Application for a non-material amendment following a grant of planning permission. Town and Country Planning Act 1990

PROPOSED SINGLE STOREY REAR EXTENSION, TWO STOREY FRONT AND REAR EXTENSIONS, DETACHED GARAGE AND ALTERATIONS TO SITE ACCESS

H01-0351-21

DETACHED GARAGE LOCATION MOVED AWAY FROM THE BOUNDARY, HIPPED ROOF CHANGE TO GABLE ROOF, ROOFLIGHTS AMENDED AND WINDOW TO GABLE ADDED

Scale 1:50 @ A1 size
drawing number :
201180-08 rev B

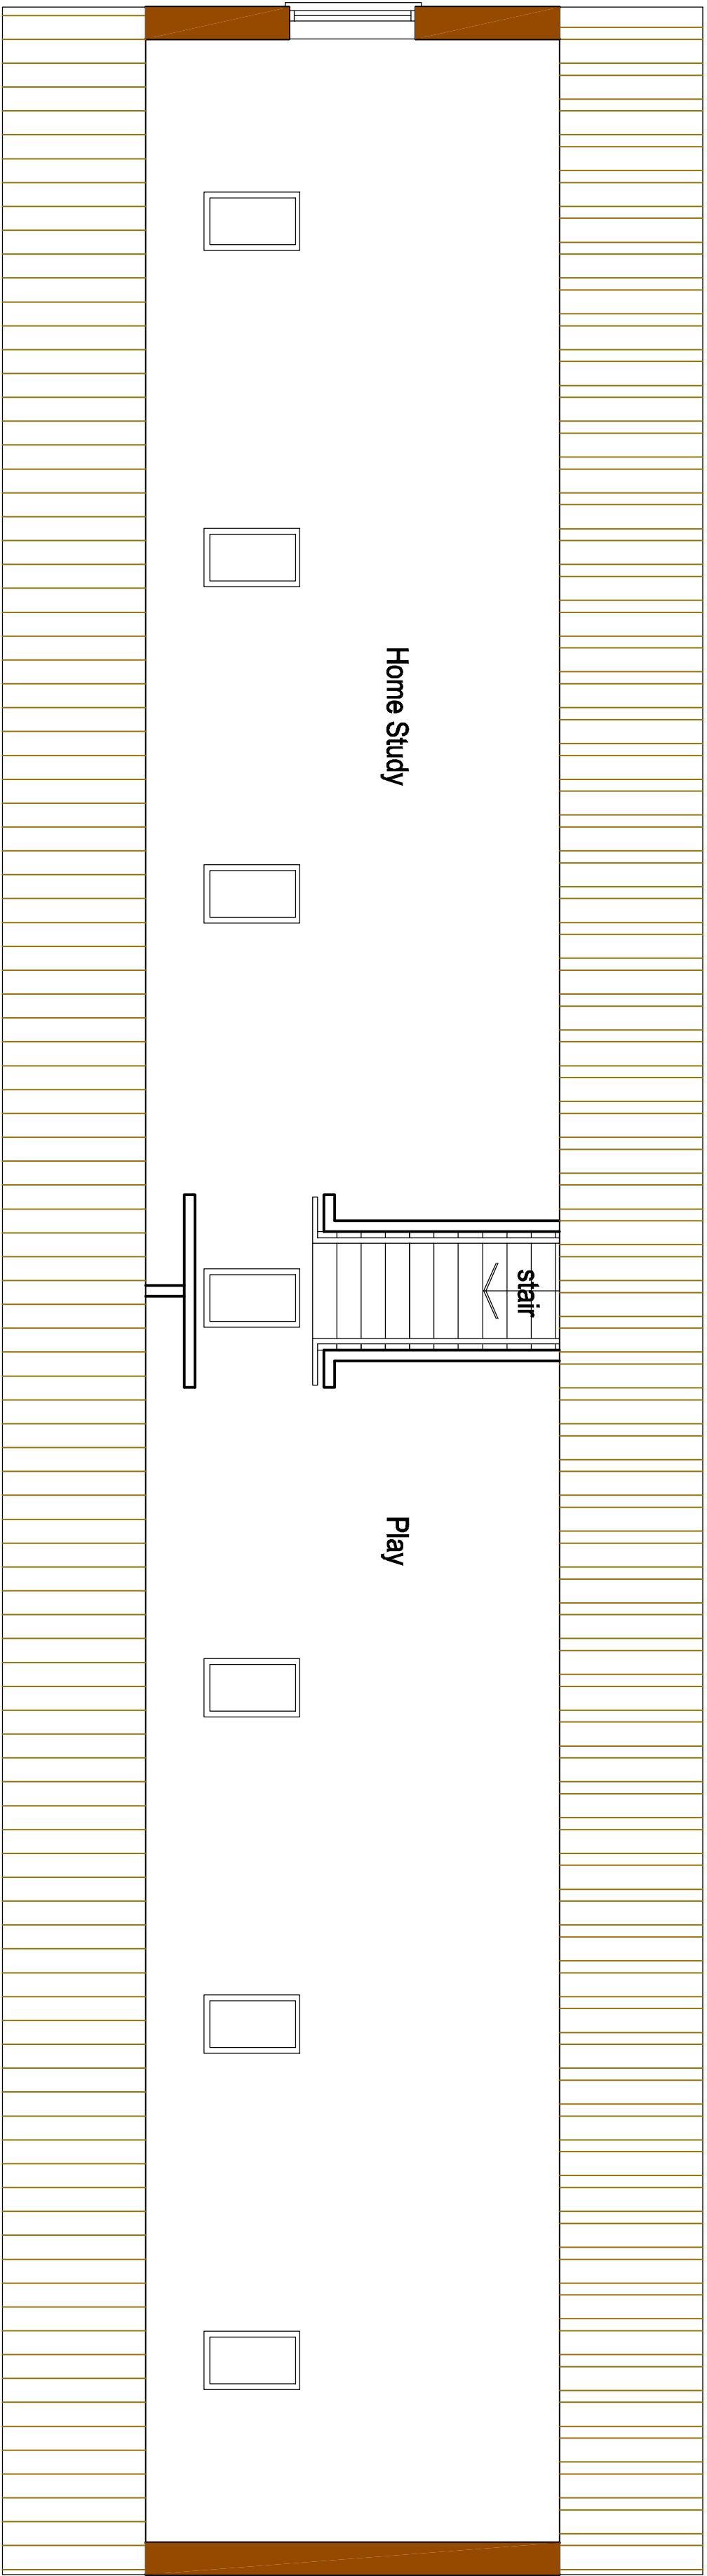
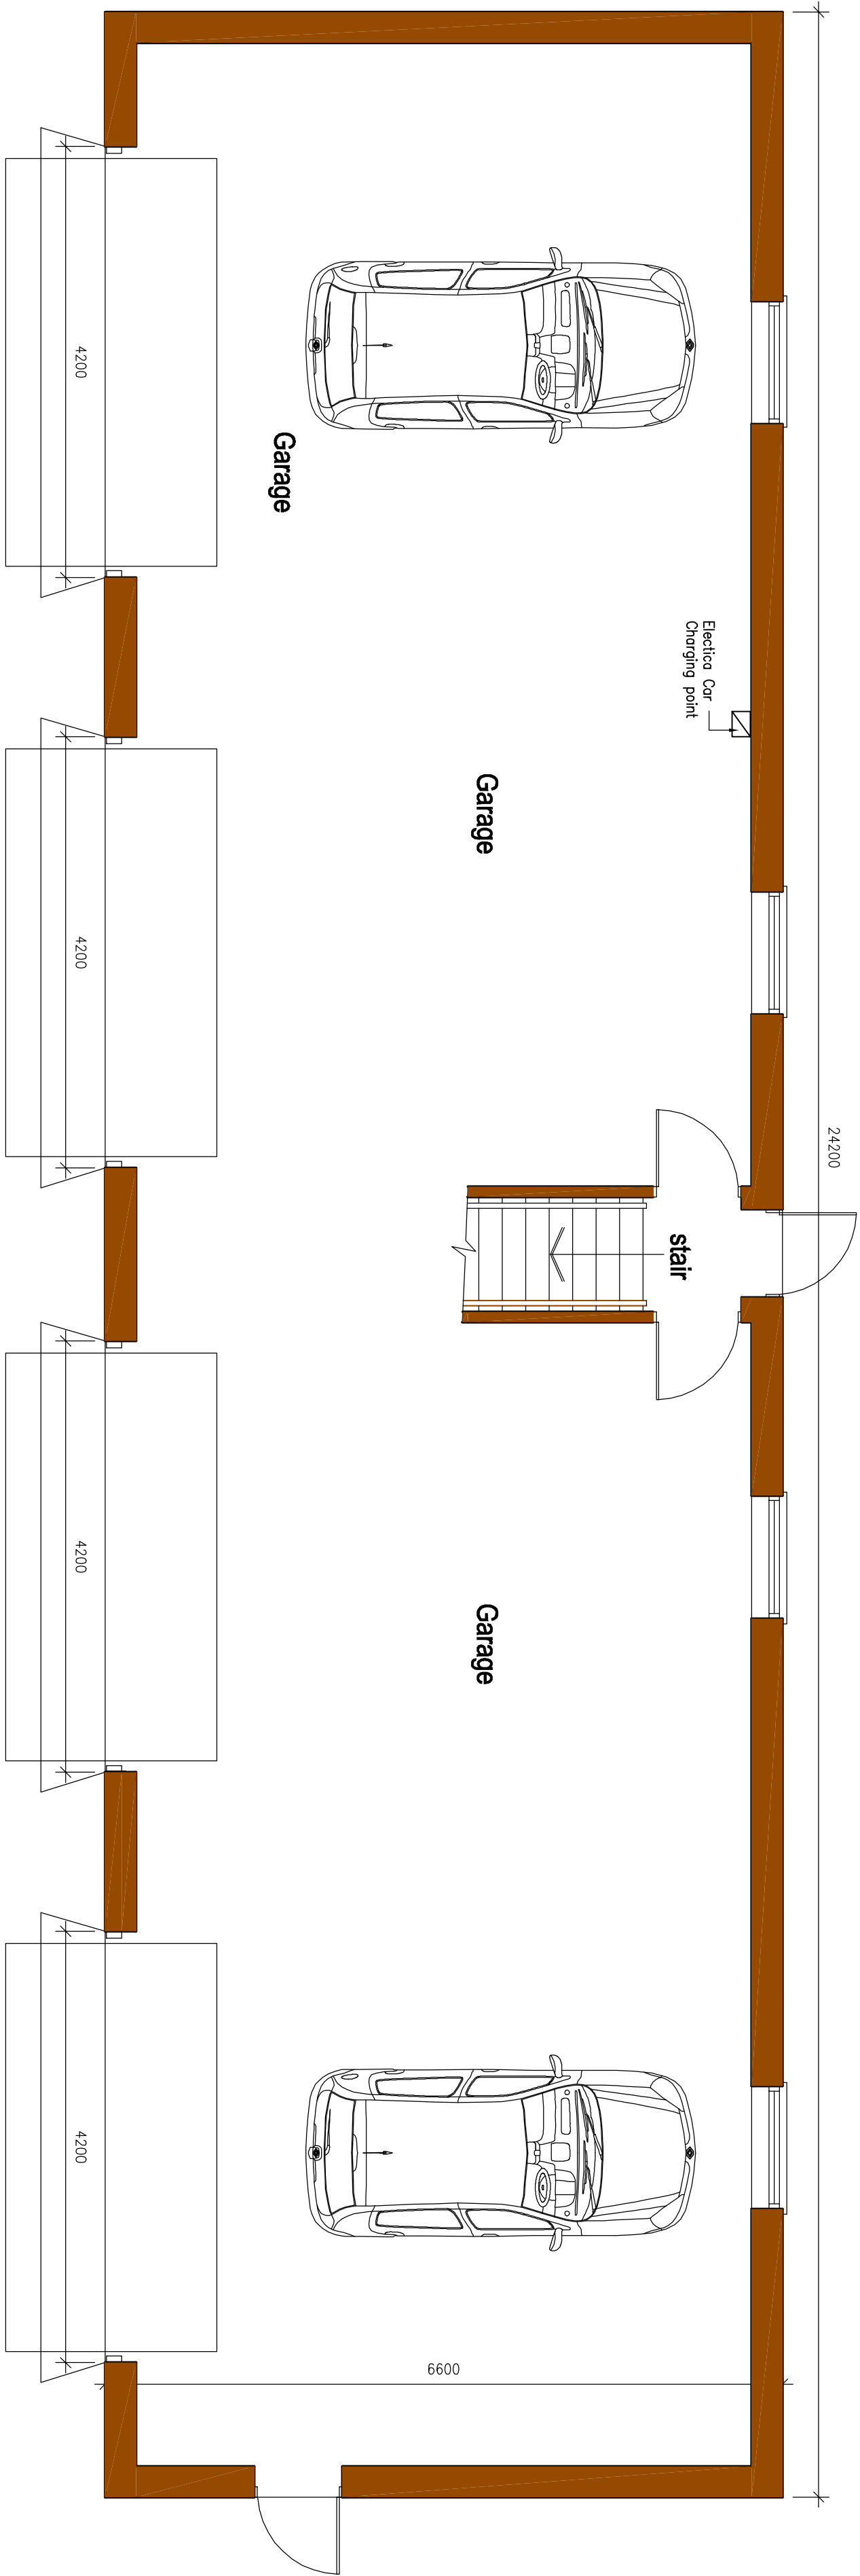
RESITING GARAGE FROM BOUNDARY TO PROVIDE ACCESS AROUND THE GARAGE, HIP ROOF TO GABLE ROOF TO PROVIDE BETTER USE OF THE UPPER SPACE, ROOFLIGHT AND WINDOW TO PROVIDE ENHANCED NATURAL LIGHT PROVISION

201180-07 REV B, -08 REV B AND -09 REV B
